Our Ref: P/82/19/HH

**Town & Country Planning Act 1990 (as amended)
Town & Country Planning (Development Management Procedure) (England) Order 2015
Application for Planning Permission for Works or Extension to a Dwelling**

Development Single storey side and part rear extension to existing bungalow

Location 23 Bishops Close Pagham

Ground floor plan

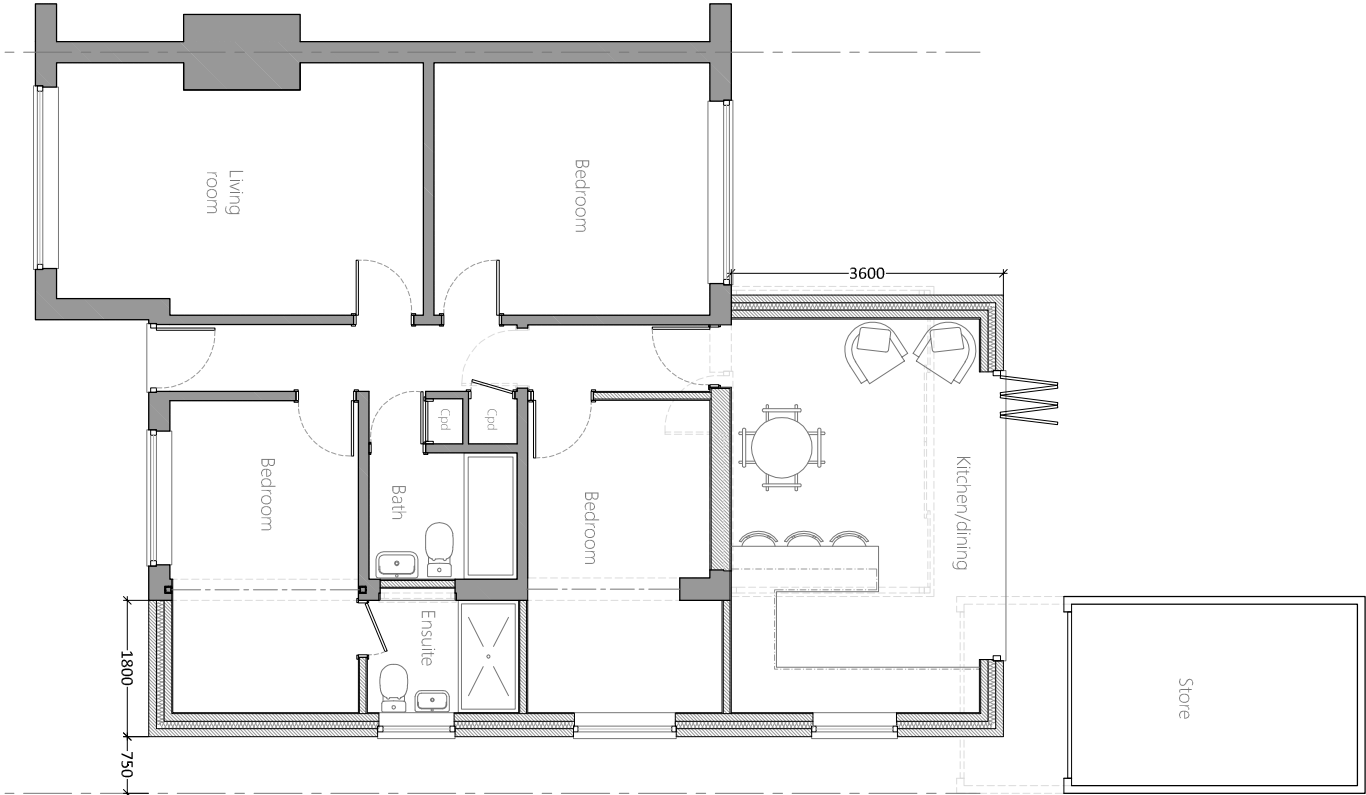
Confirmation: Are you converting the garage to a store under this application? If so you will need to add to description, with your permission we can add this for you.
